Recommendation Report for Prior Notification of Work to Tree(s) in a Conservation Area

REF NO: WA/48/21/TC

LOCATION: Walberton House
The Street
Walberton
BN18 0PJ

PROPOSAL: Removal of 1 No. Ash (T1) because of Ash die back.

Figure. 1 Ash (T1) Showing overhang of car-park

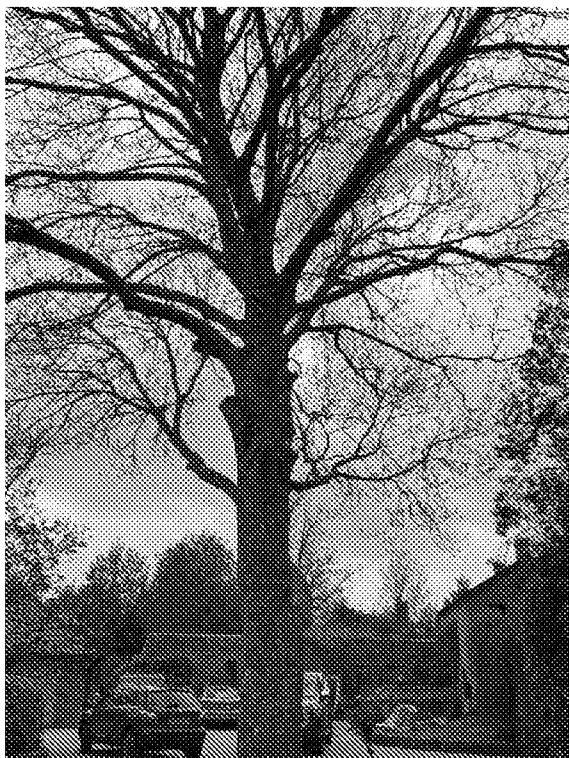
My inspection was limited but from a distance (roadside and from gated entrance) this tree appears to be outwardly healthy and stable with a relatively unmodified and attractive crown profile. (See photos at foot or report). It is a valuable constituent of the mature high canopy that collectively make an important contribution to the character of the surrounding area.

The applicant is seeking to remove the tree on the grounds that it is diseased and likely to become hazardous. I did not observe any obvious symptoms of Chalara infection (ash dieback) - on the contrary, the tree appears to be in good condition. That is not to say the tree is not infected, but in the absence of clear evidence of significant disease we should proceed on the basis that it is healthy and may remain so.

I did not see any large lesions on the scaffold limb framework, although a recently formed 'hazard beam' (longitudinal split) had opened on an east-tending limb low in the crown. Deadwood content did not

appear obviously problematic or indicative of disease.

It has not been satisfactorily demonstrated that this tree is or likely to become hazardous in the near future, as a consequence of Chalara (ash dieback) infection.

The tree is an attractive feature in the local street-scene, contributes positively to the character of the area and appears to be in adequately sound and healthy condition.

I recommend the making of a Tree Preservation Order to preserve its place in the landscape and better control its future management. I attach a TEMPO form and GIS plan for this purpose.
